App No: EG/7/19/PL

Address: 26 Downview Road Barnham PO22 0EG

Proposal: Demolition of existing detached dwelling & garage & erection of 1 No. dwelling with car port.

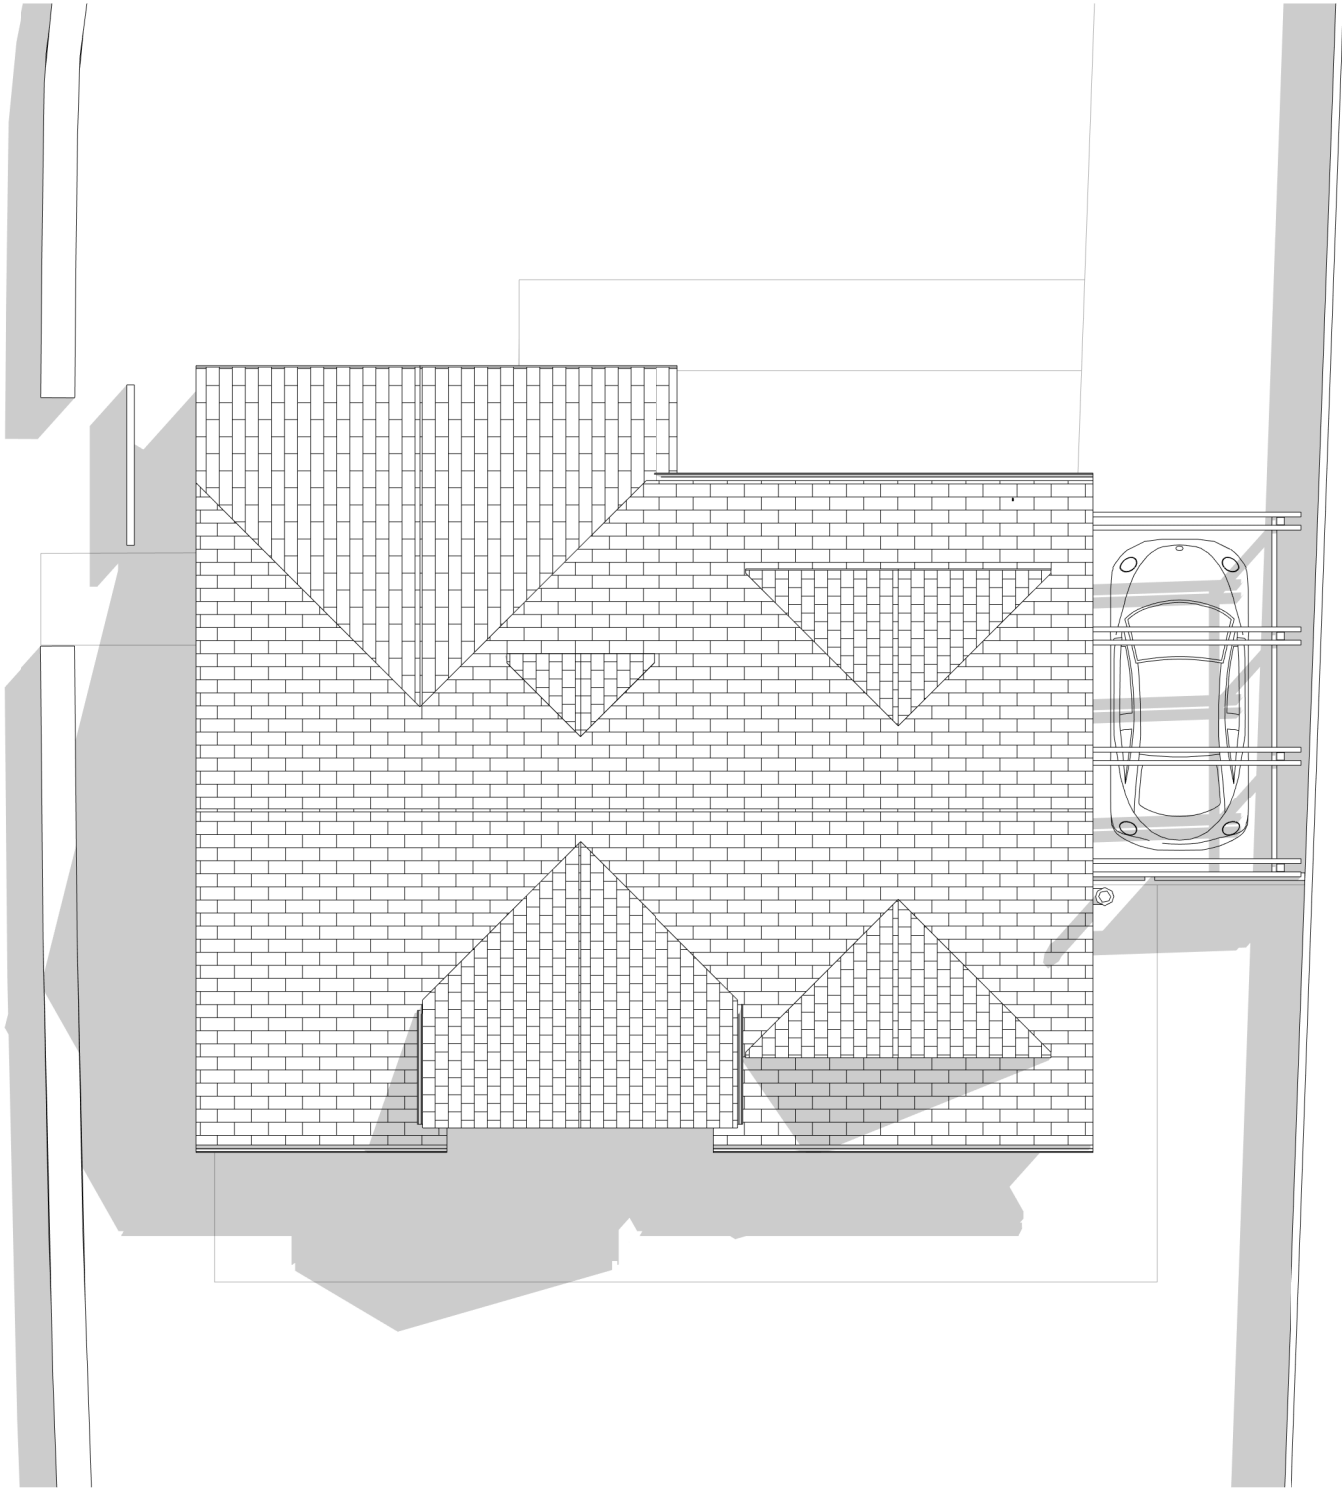
Following submission of the Phase two bat surveys (May 2019) we are satisfied that bats are not roosting within the property onsite and no further survey work is required for bats. As a precautionary approach the roofing felt should be used and breathable roof membrane or fibrous materials should be avoided.
